Our Ref: SO32-T00009

Eurobodalla Southern Storage SSD 7089 – Roadworks Construction Environmental Management Plan and Construction Flora and Fauna Management Plan

Figure 1.1 Eurobodalla Southern Water Supply Storage project overview

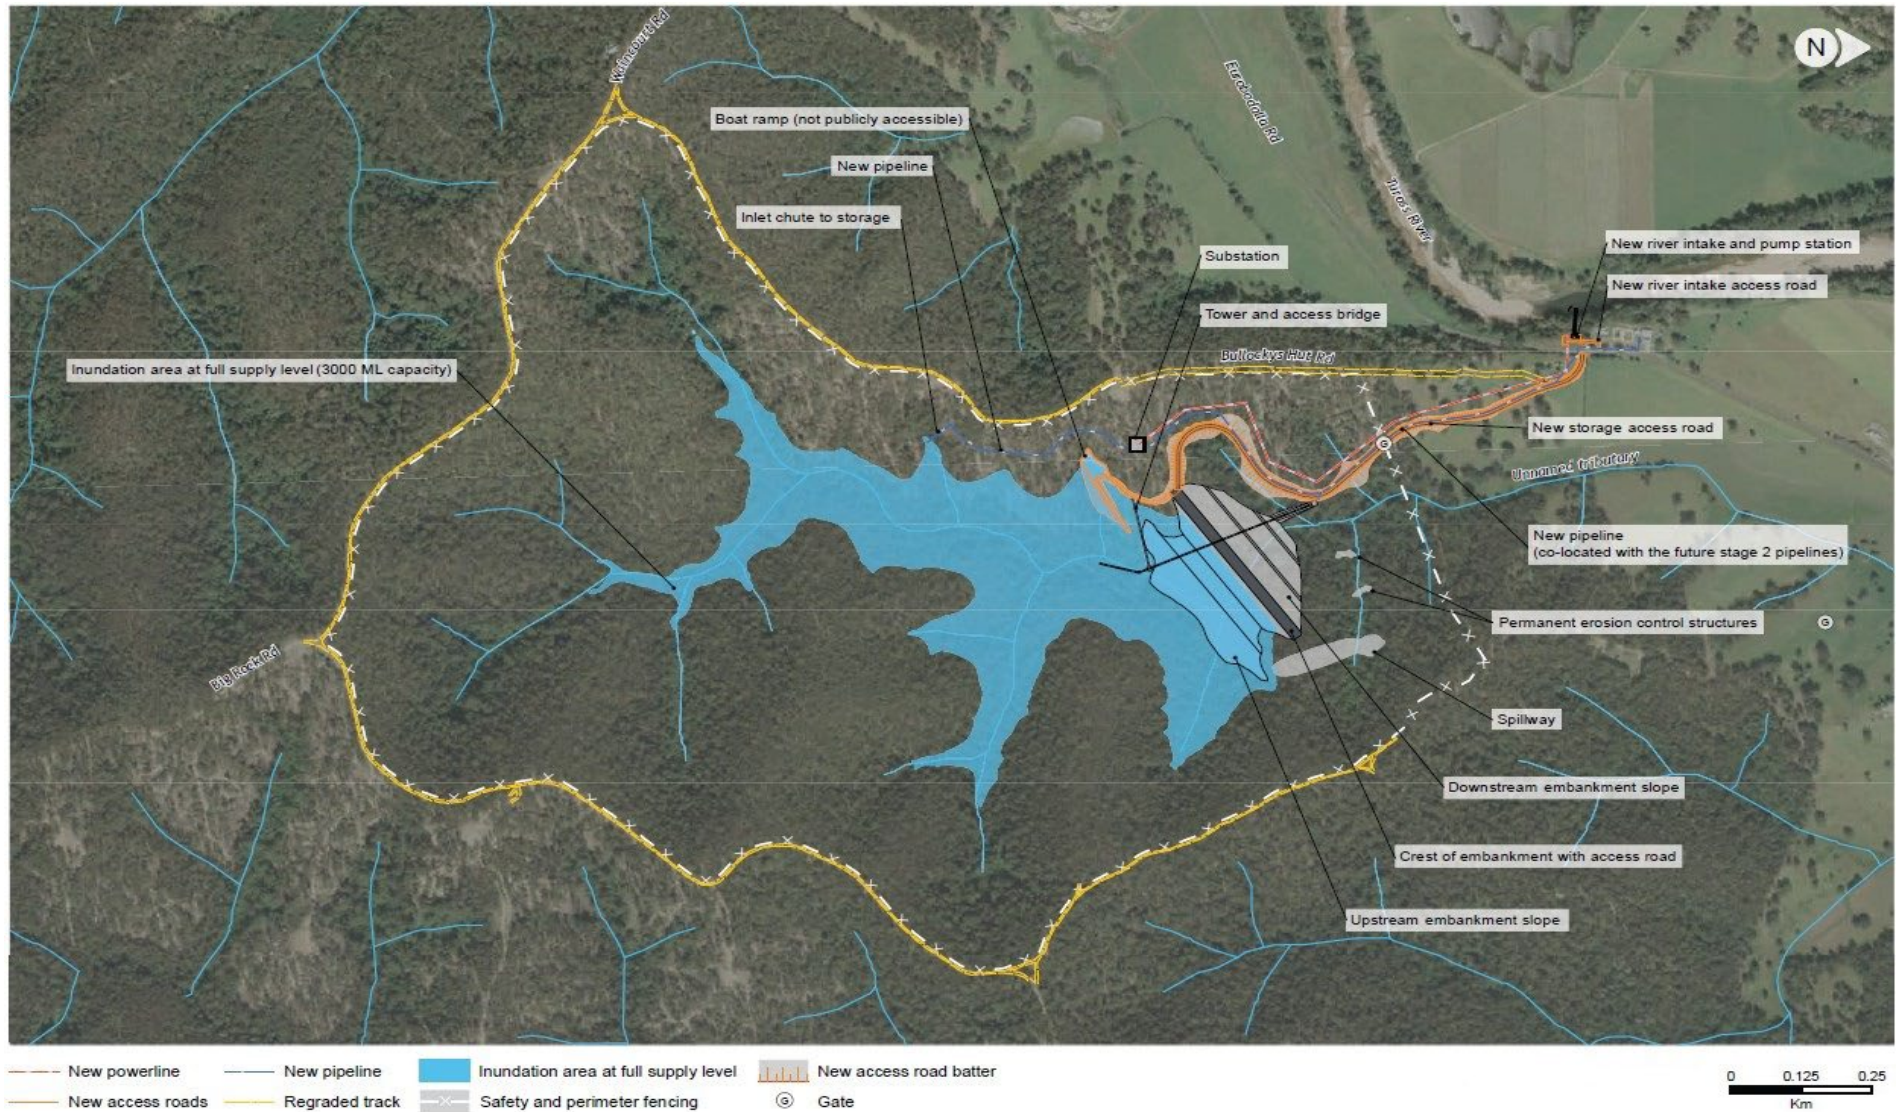
- Protection of Hollow Bearing Tree (HBT 1) clarified in CFFMP, with an additional no-go zone specified around this tree.
- Inclusion of proposed no-go zones in Figure 1-1 of the CEMP.
- Justification of need to undertake works prior to February-March in CFFMP, and expansion of proposed mitigation measures for clearing the identified wet sclerophyll forest, based on actual current site conditions and nesting and breeding habits of identified threatened species.
